PROJECT: BOYLE RESIDENCE
DRAWING TITLE: MERCER ISLAND, WA
GENERAL NOTES

PERMIT SET

**BOYLE RESIDENCE
 MERCER ISLAND, WA
 FOUNDATION & FIRST FLOOR
 FRAMING PLANS**

PROJECT	BOYLE RESIDENCE
DRAWING TITLE	FOUNDATION & FIRST FLOOR FRAMING PLANS
DATE	07/25/17
REVISION	
SHEET NO.	S2.1

GARAGE FOUNDATION PLAN (ADU LEVEL)

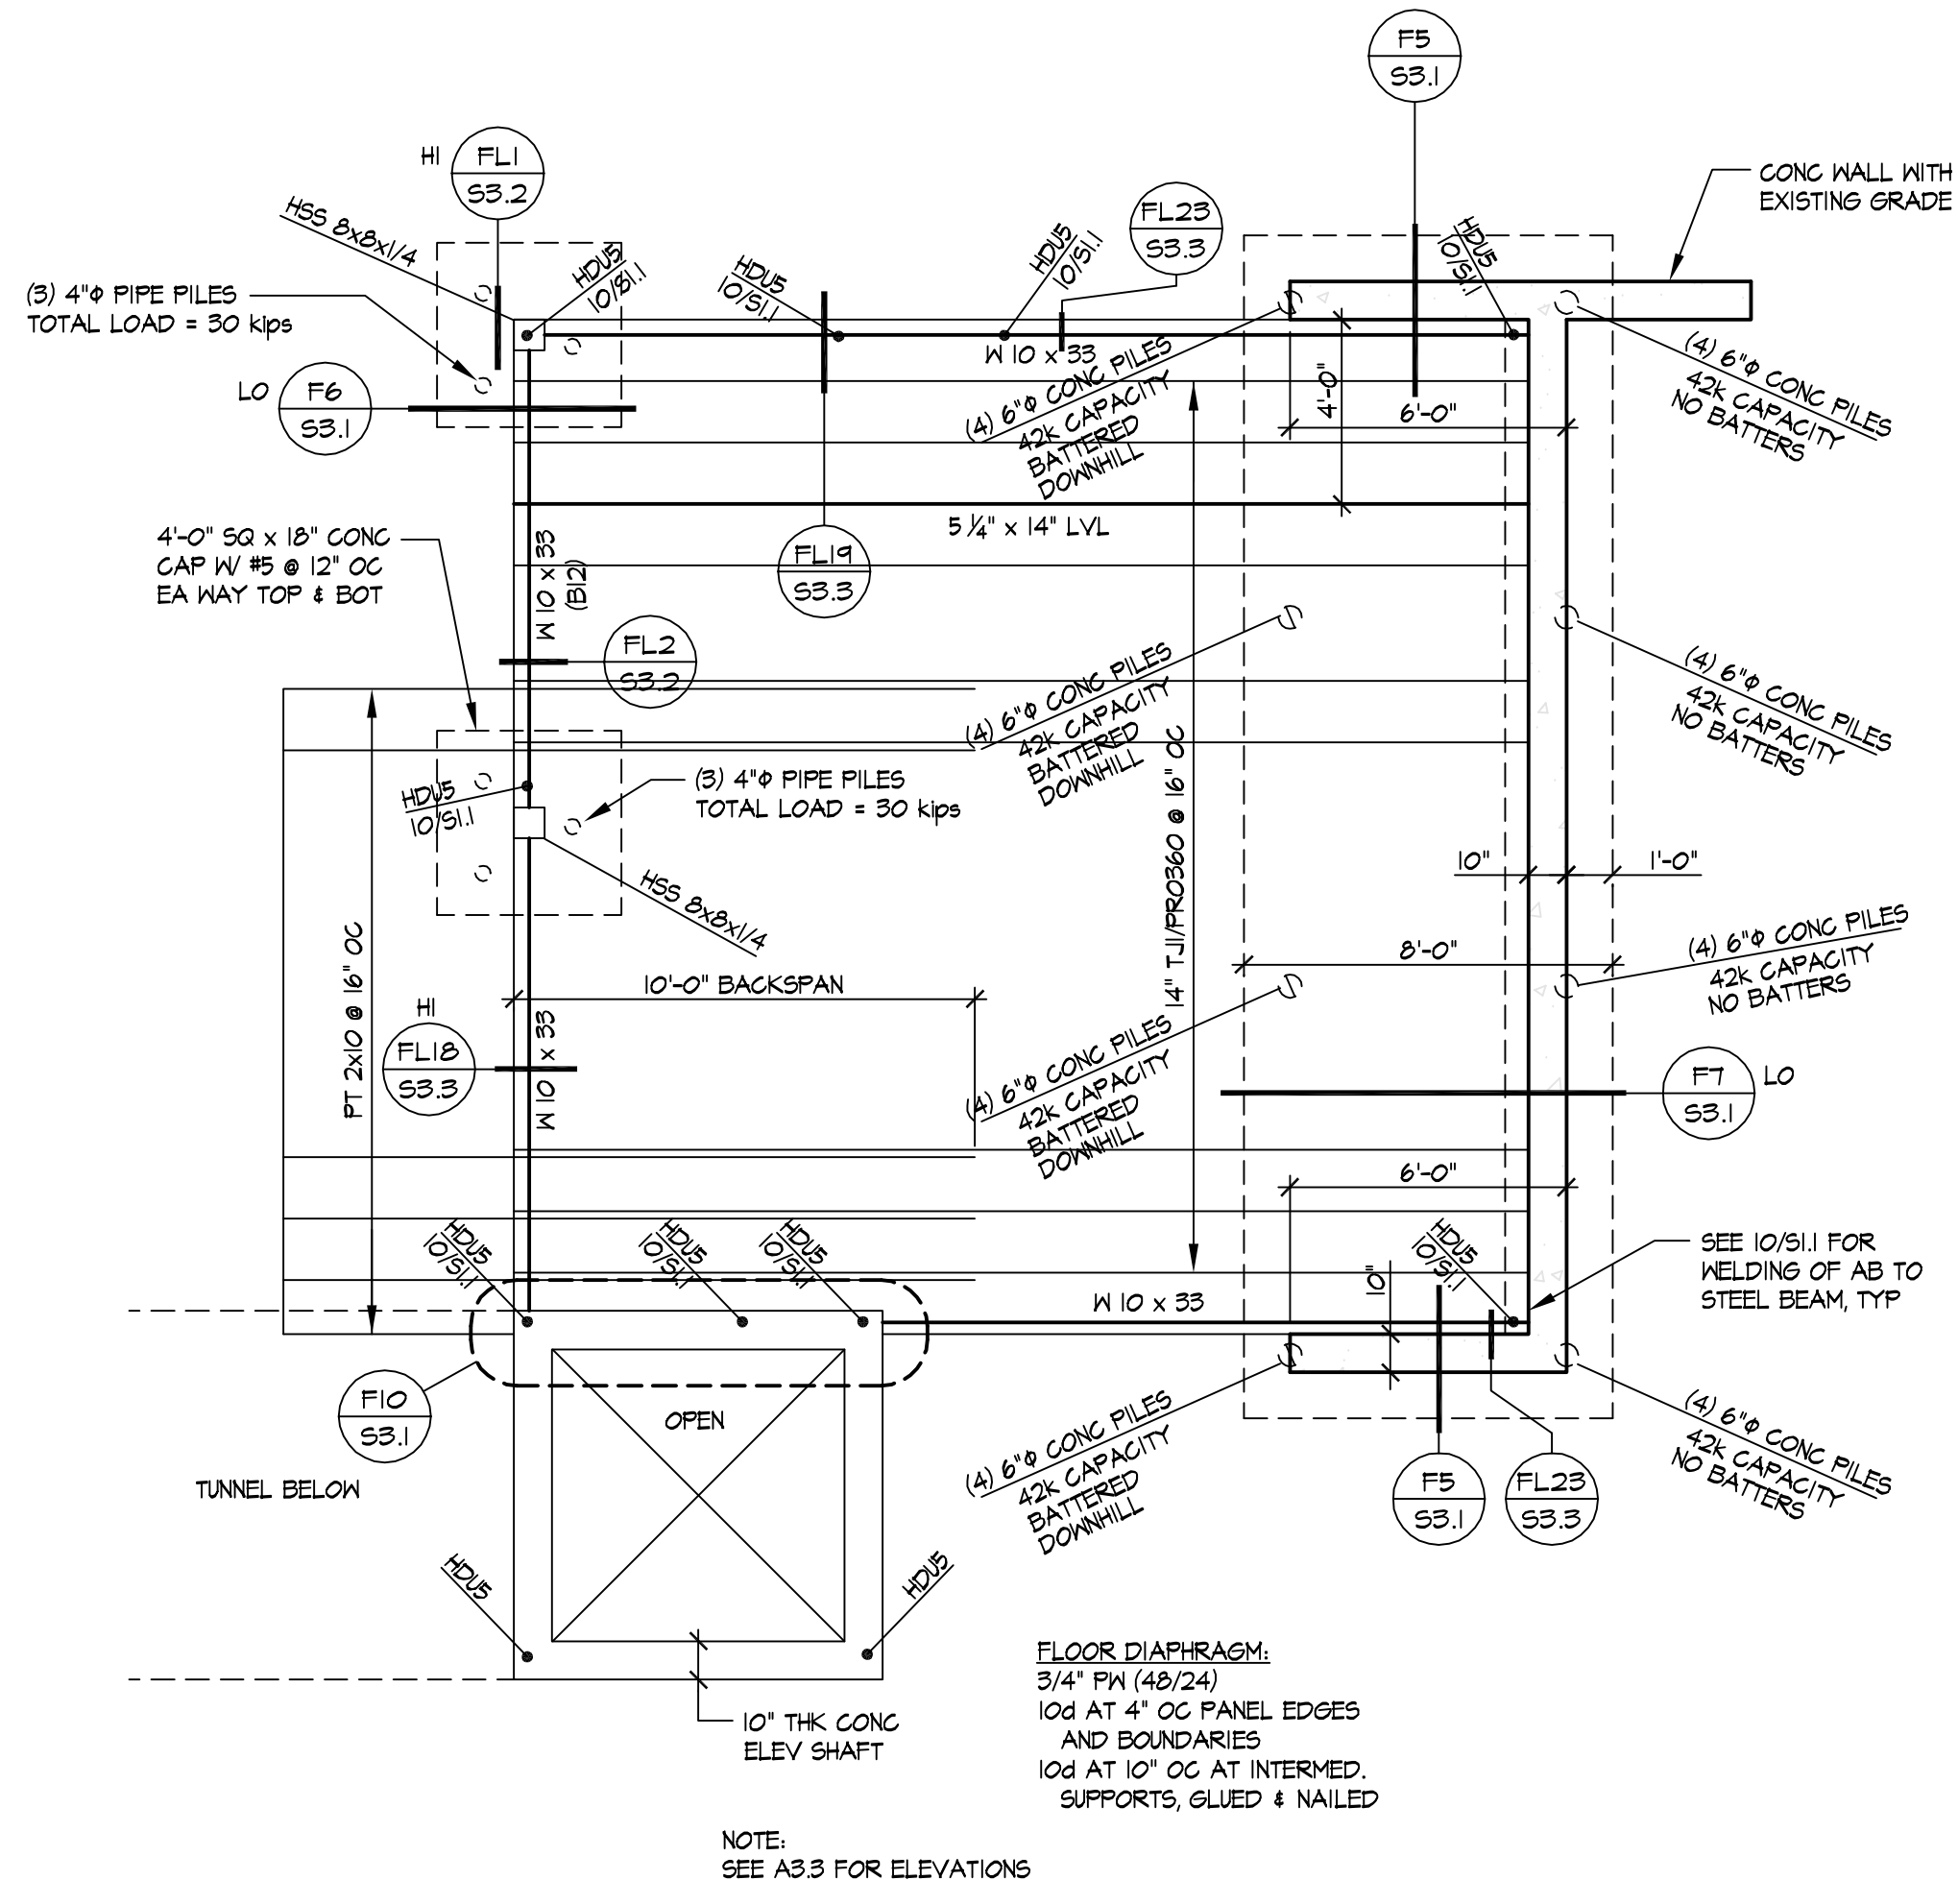
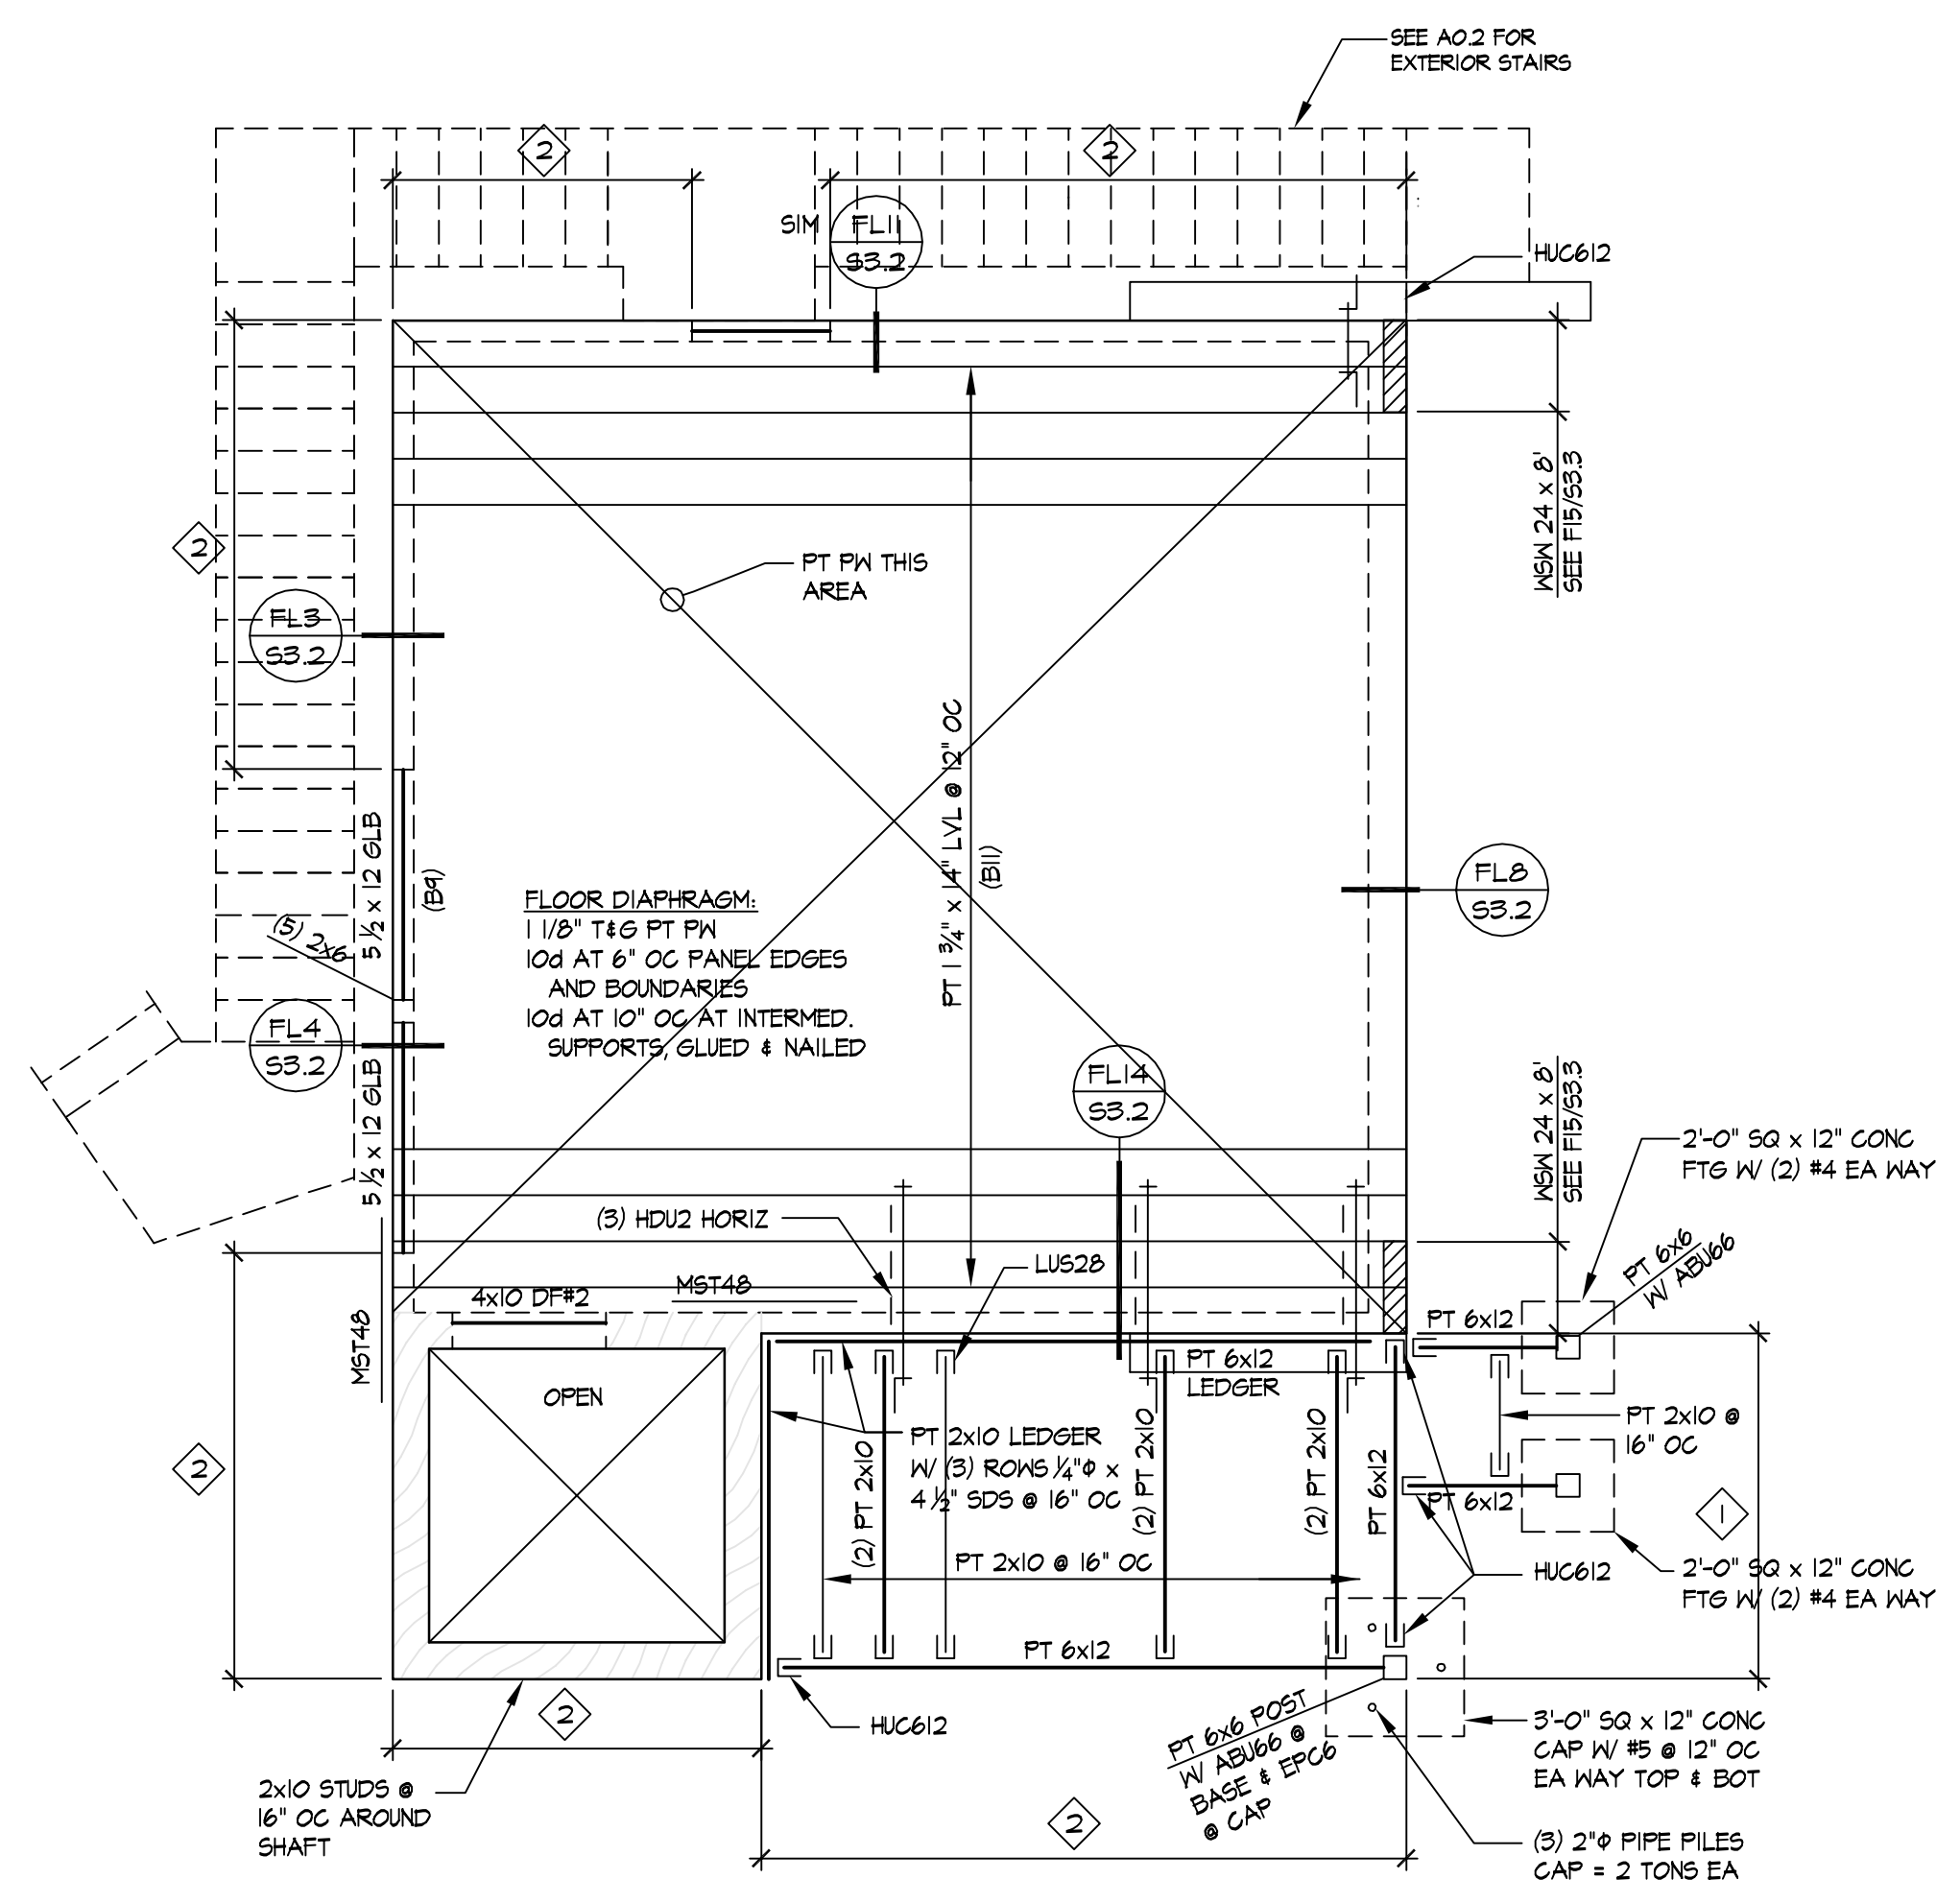
Building Review (paul.skidmore@mercergov.org)
Comment #1
Provide detail showing how portions of structure are "interconnected" as required by ASCE Section 12.1.3. Provide appropriate attachment between separate elements of the structure as required. Alternatively, provide appropriate separation joint between building portions as required by ASCE Section 12.12.3.

Building Review (paul.skidmore@mercergov.org)
Comment
Provide complete structural calculations and detailing for concrete elevator shaft. If intended to resolve lateral forces, provide special reinforced concrete shearwall design per ACI 318 Section

Building Review (paul.skidmore@mercergov.org)
Comment
Provide positive lateral connection for deck to main structure. DTT2Z are noted, but are not capable of developing code required forces.

Building Review (paul.skidmore@mercergov.org)
Comment #1
Provide detail showing how portions of structure are "interconnected" as required by ASCE Section 12.1.3. Provide appropriate attachment between separate wings as required. Alternatively, provide appropriate separation joint between building portions as required by ASCE Section

Building Review (paul.skidmore@mercergov.org)
Comment
Confirm by calculation capacity of ledger to resolve point load from 6x12 beam.

Building Review (paul.skidmore@mercergov.org)
Comment
Provide detail / elevation callout for WSW. Indicate
